Re: Exhibition - State Significant Development Application (SSD-8865-MOD-3)

PROPOSAL:	St Anthony of Padua Catholic School Redevelopment: Mod 3 – Amendments to Staging, Site Layout and Built Form (SSD-8865-MOD-3)
ADDRESS:	135-165 Tenth Avenue and 140-170 Eleventh Avenue, Austral NSW 2179 (Lots 810 - 811 DP 2475; Lots 840 - Lot 842 DP 2475; Cnr Lot 1 & Cnr Lot 2 DP 1232692)

CONCEPT PROPOSAL  
SITE PLAN

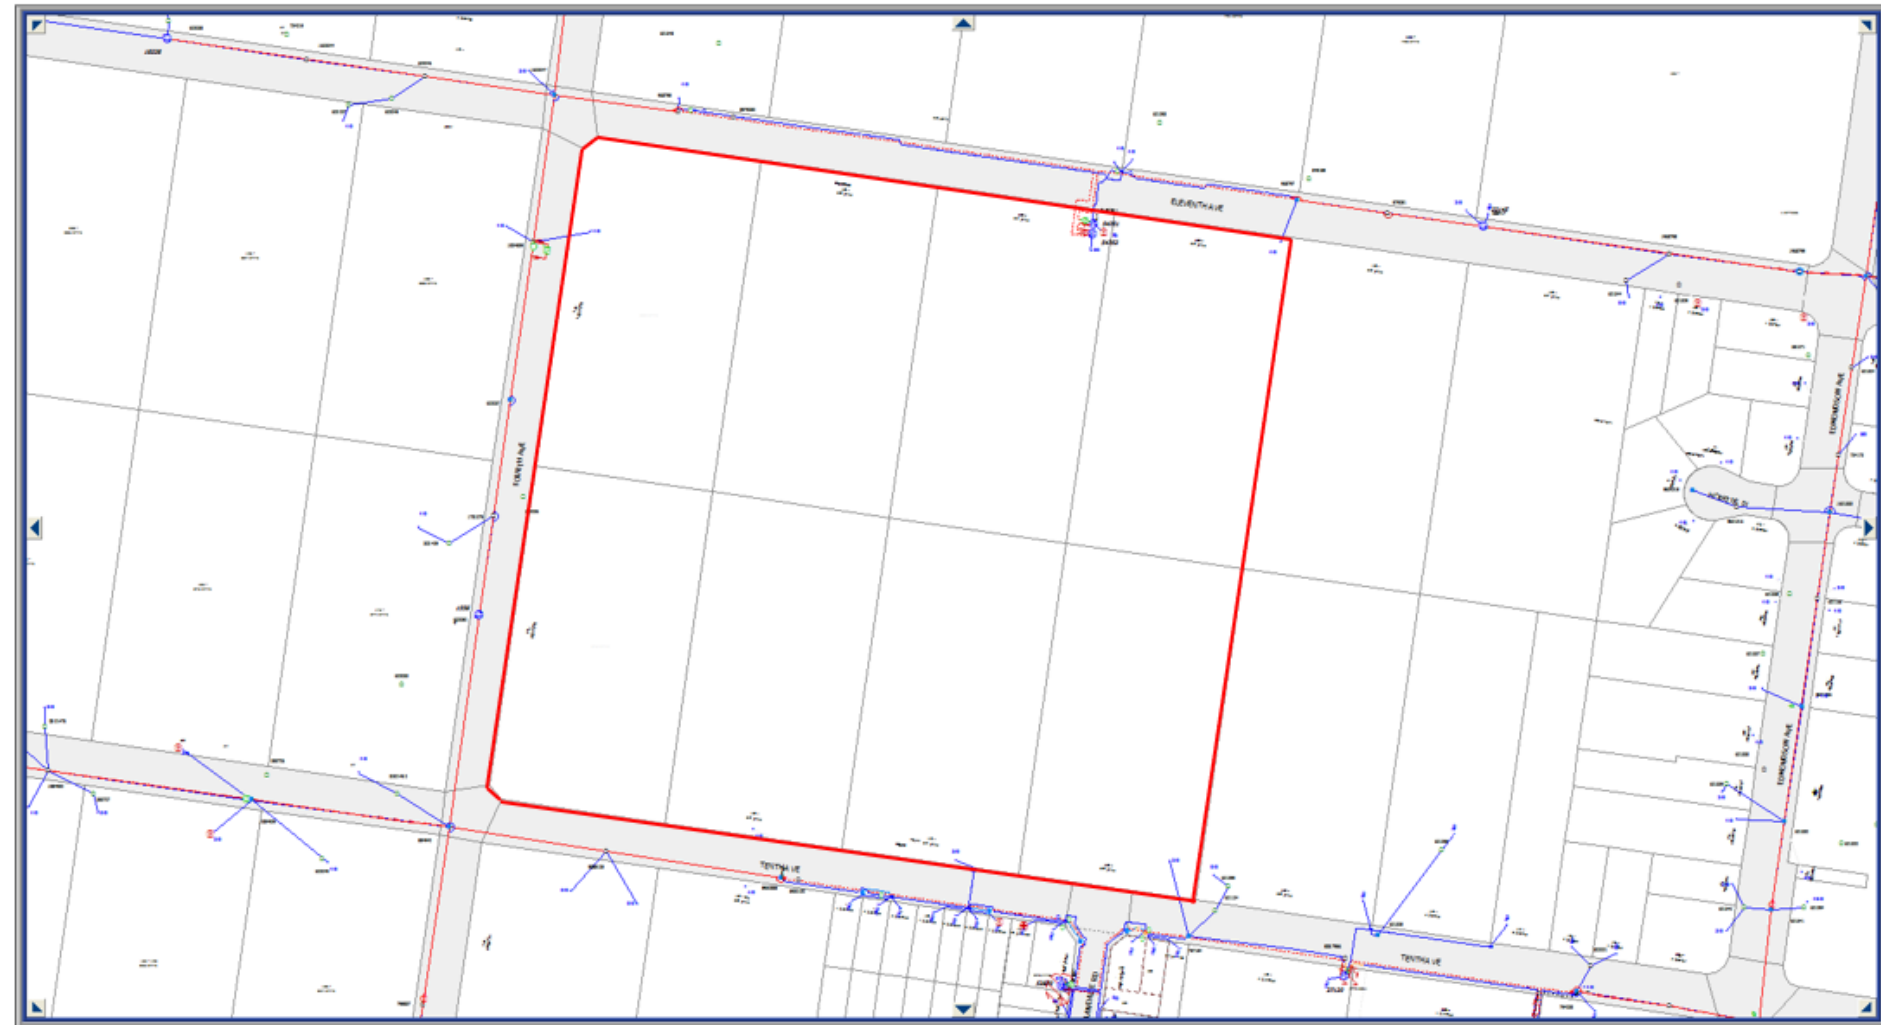
The modification of the vehicular access from Eleventh Avenue is generally supported. However, it is recommended that the applicant include appropriate traffic calming devices at these entrances and throughout the car parks to ensure the safety and priority of pedestrians.

As mentioned in the submitted Road Safety Audit (RSA) report, the two driveways off Eleventh Avenue should be operating as a one-way entry or exit only driveway. Traffic flow pavement marking should be provided within the carparks to guide traffic circulation within the carparks.

It is noted that the proposed EV charging station will be located adjacent to four accessible spaces and near a pickup/drop off area. To avoid impacts, consideration should be given to locating any EV charging stations in areas with low traffic movements such as long-term or staff parking areas.

- d) Amended plans and documentation demonstrating that the EV charging stations will be located in low trafficable areas such the staff carpark or long-term parking areas.

- e) Amended plans and documentation showing pedestrian crossings at key entry points such as the entry/exit ways of all car parks across the site. Refer to the Western Sydney Street Design Guidelines for street components relating to traffic calming devices.

The proposed modifications to the parking provisions are generally supported across the site. However, there is concern that 1 EV charging station will not be sufficient for a site of this size to cater for the growing number of electric vehicles. It is recommended that the applicant justifies the number of EV charging stations provided and ensures that all parking spaces are adaptable to cater for any future demand for EV charging stations.
